February 15, 2018

Subject: TimberRidge Planned Unit Development (PUD-17-003) **Review 5.5**

This letter responds to your letter dated February 12, 2018 regarding the subject project. Responses to comments are shown in **RED** below the comment.

PUD Development Plan

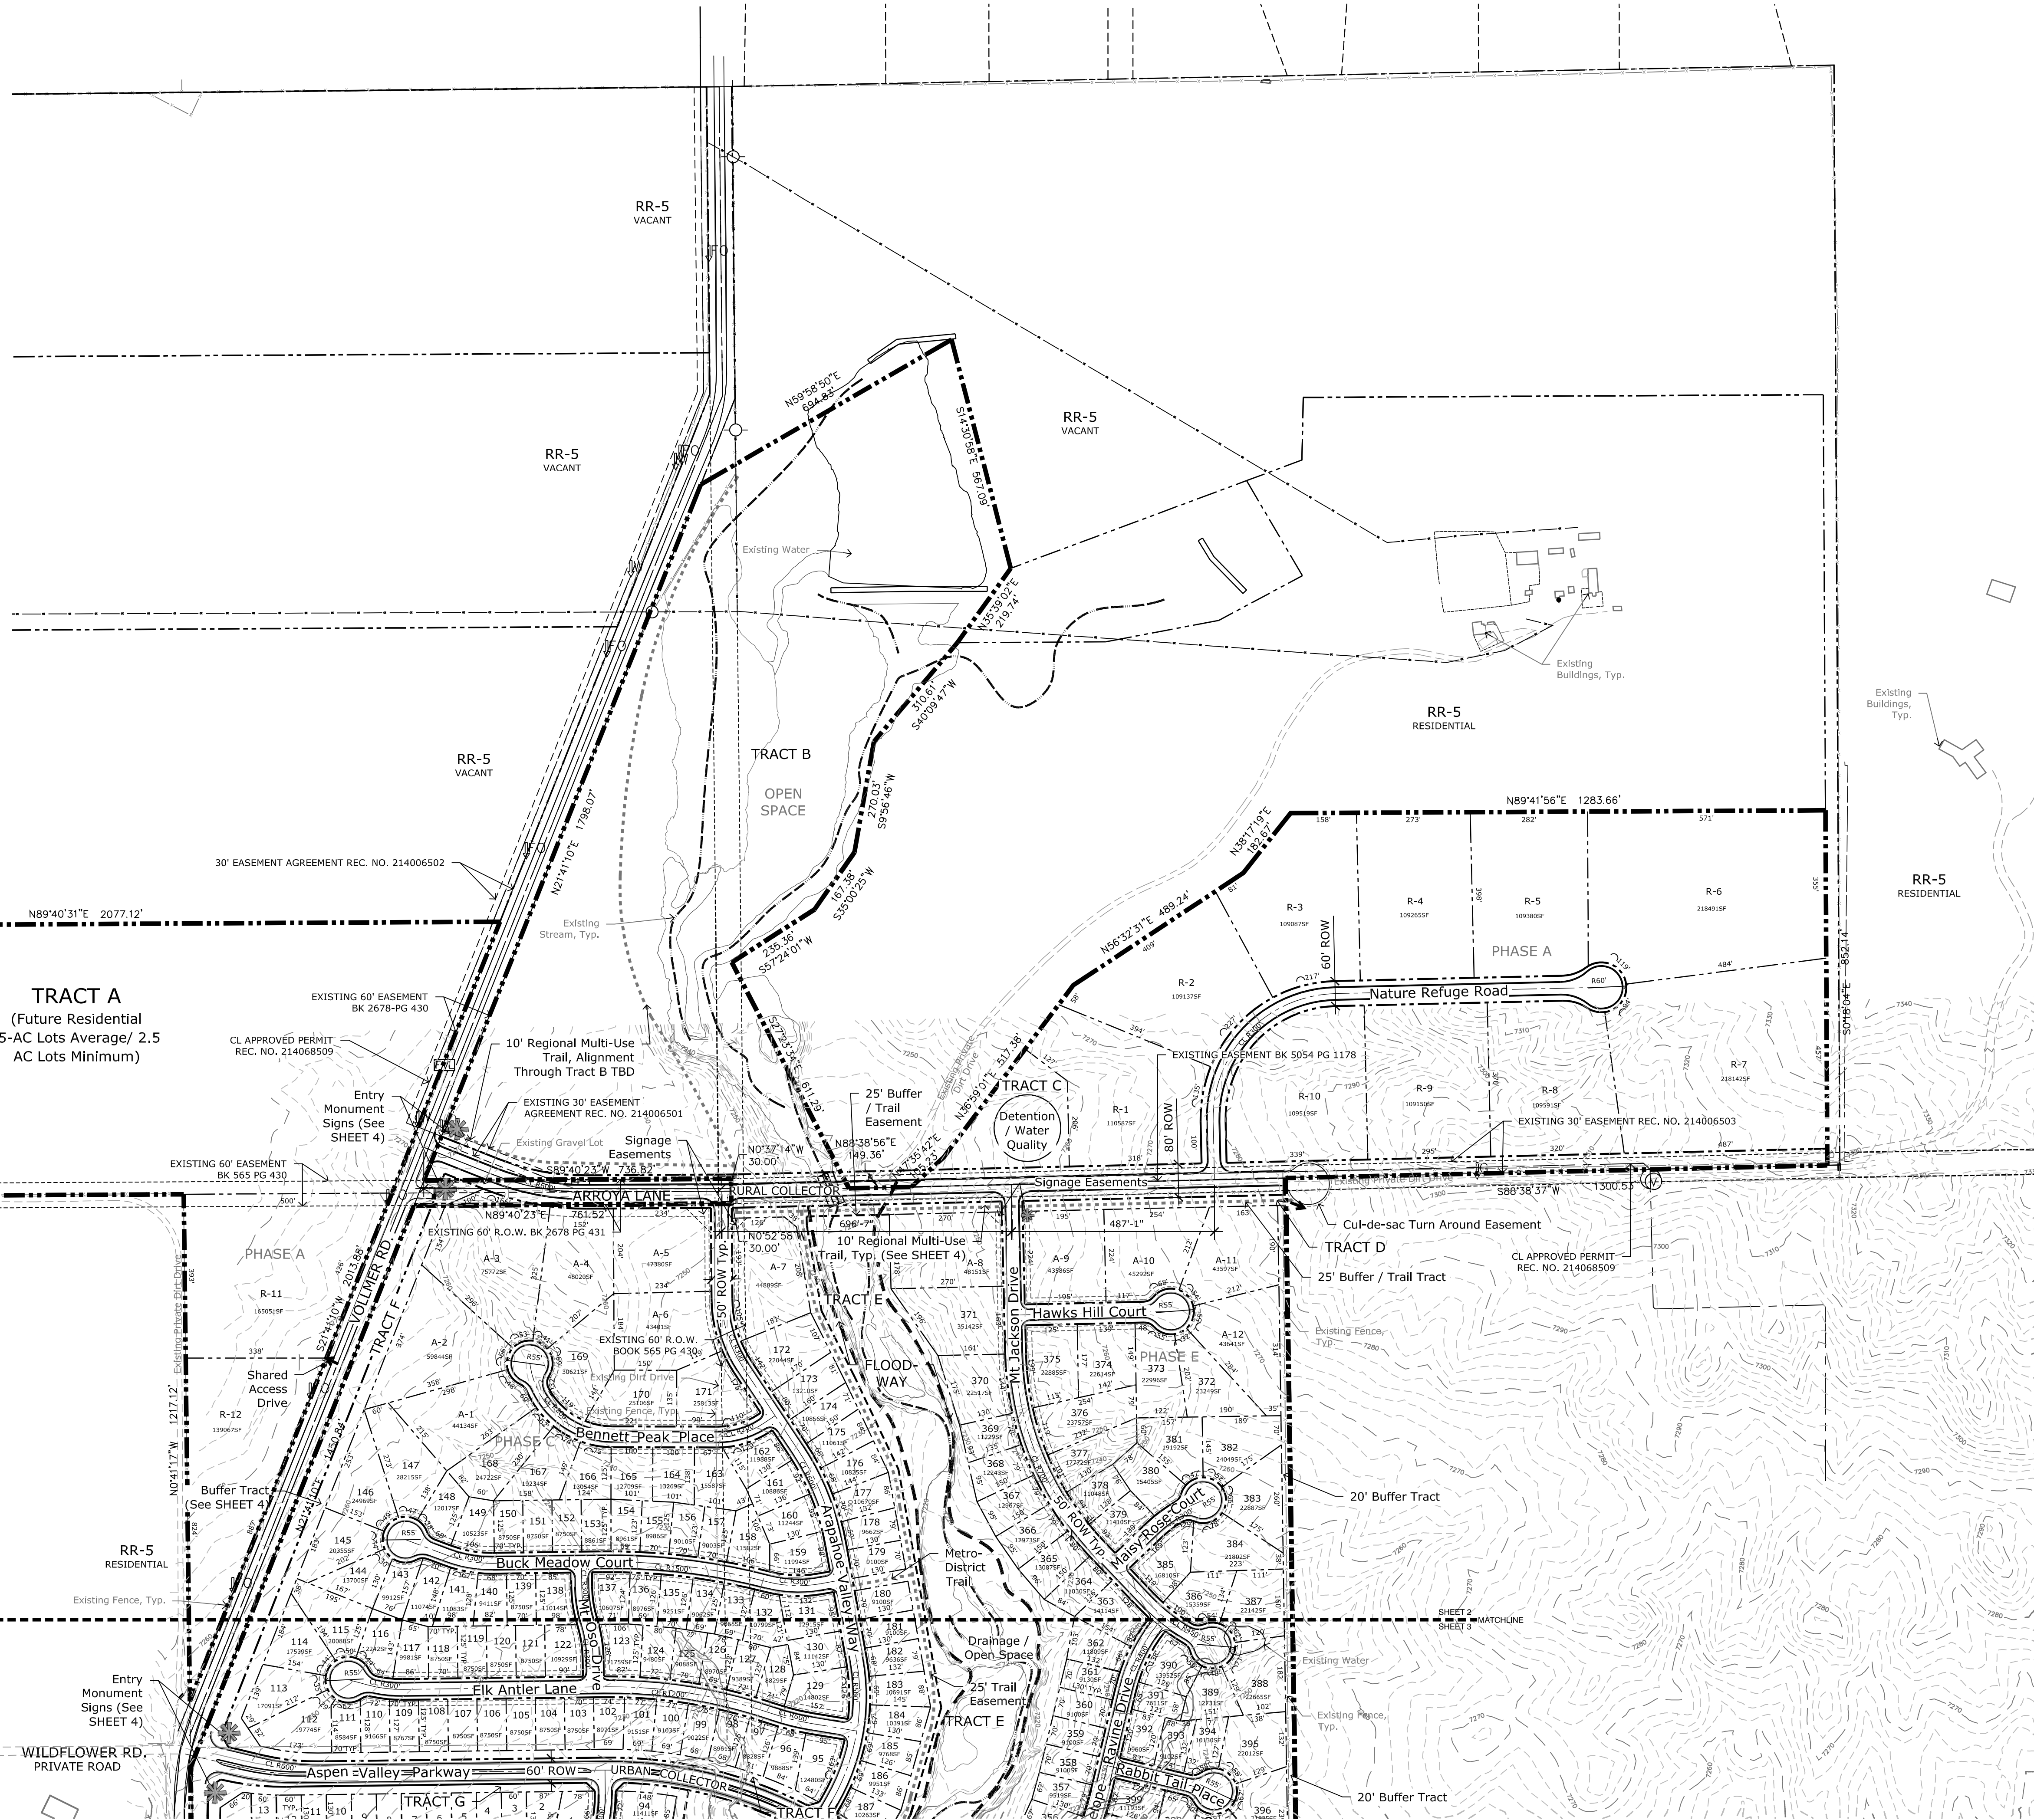
1. Ensure that all street centerline radii, intersection spacing, roundabout size, required tangent lengths, etc. meet criteria. Without dimension labels these cannot be verified. Approval of the PUD development plan does not imply approval of any substandard design features that have not been specifically addressed.

- d. Cul-de-sac design needs to meet ECM Section 2.3.8. Snow storage areas/easements need to be provided for cul-de-sacs and roads adjacent to or within adjacent property. Partially resolved; response references a letter from the adjoining property owner stating that easements will be provided. This will be further addressed at the Preliminary Plan and Final Plat stages.

- e. **Add required dimensions to the revised areas. Dimensions added.**
2. Include existing easement purposes in labels or notes. Show all easements listed in the title work. **Partially resolved; label the easement purposes/uses. Unresolved. Labels added to easements.**
